Re: Thorp Landing Plat, LP-23-00001

Response to Comments Matrix

Drawing file: LP-23-00001 Thorp Landing / LP-23-00001 Thorp Landing Preliminary Plat Map Updated 1-25-23.pdf

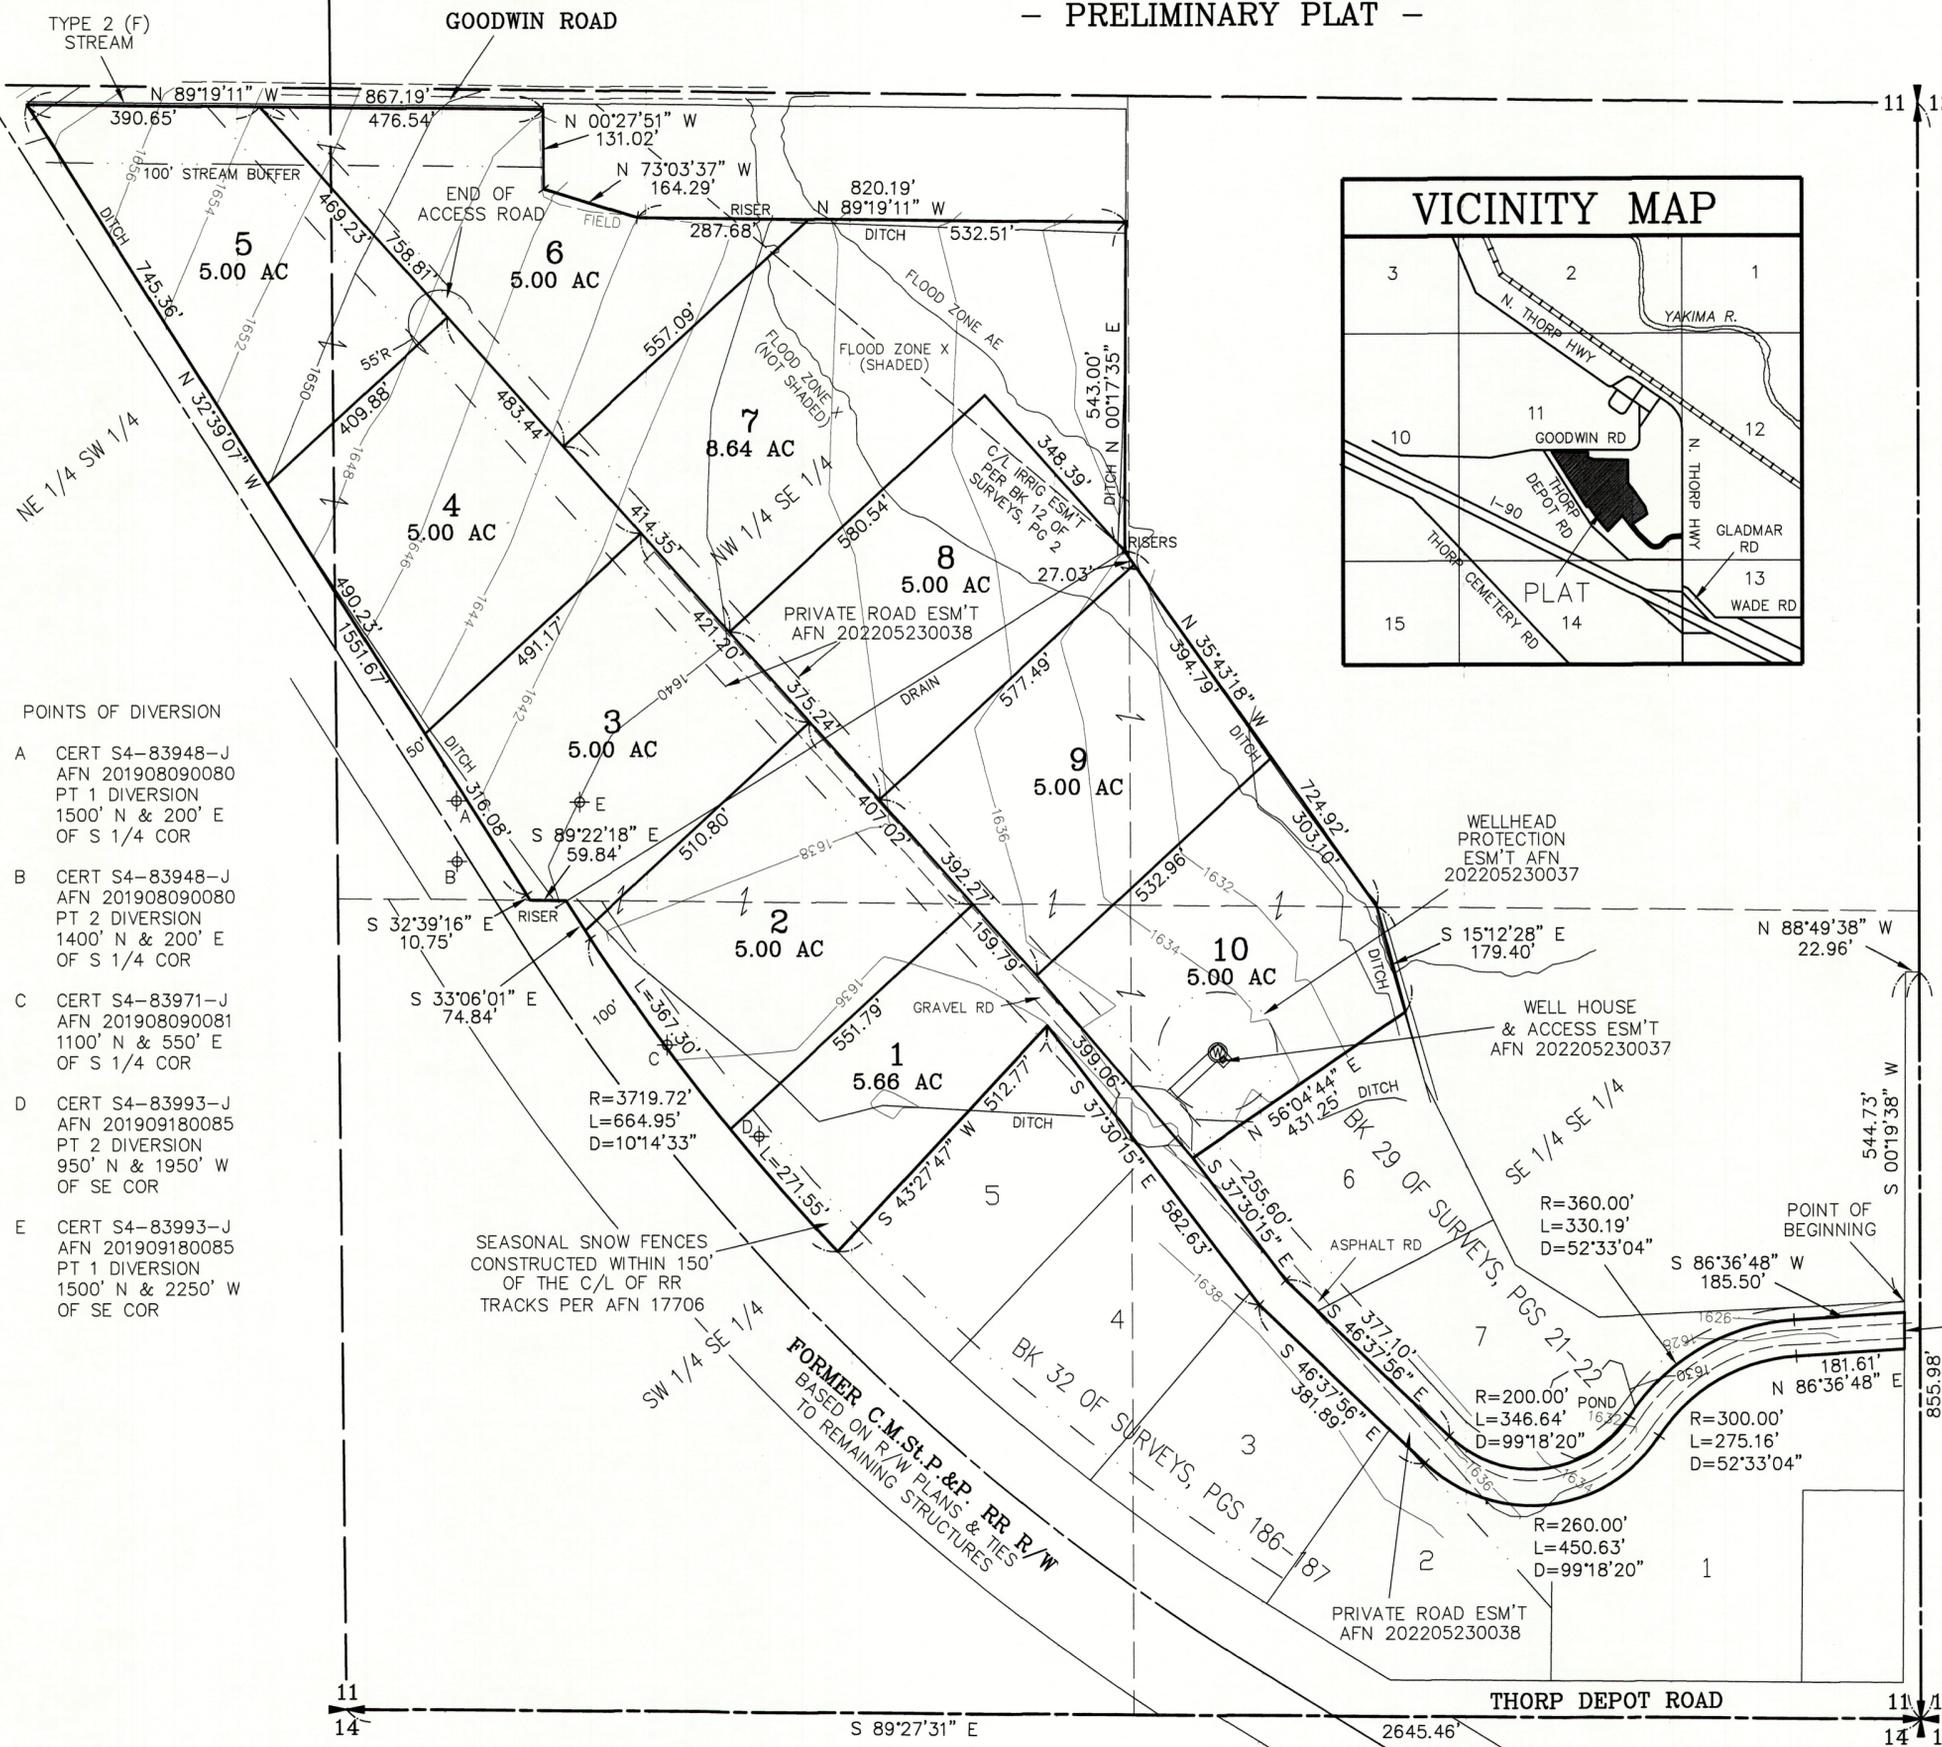
4. Roads longer than 150' in length are required to provide a fire apparatus road turnaround meeting the requirements of Appendix D in the International Fire Code.	Agreed. The preliminary plat map reflects the location of the turnaround.

Please include a NOTE: that lot access is to be only to the internal private road, and no direct access from an individual lot onto the county road.	Agreed.
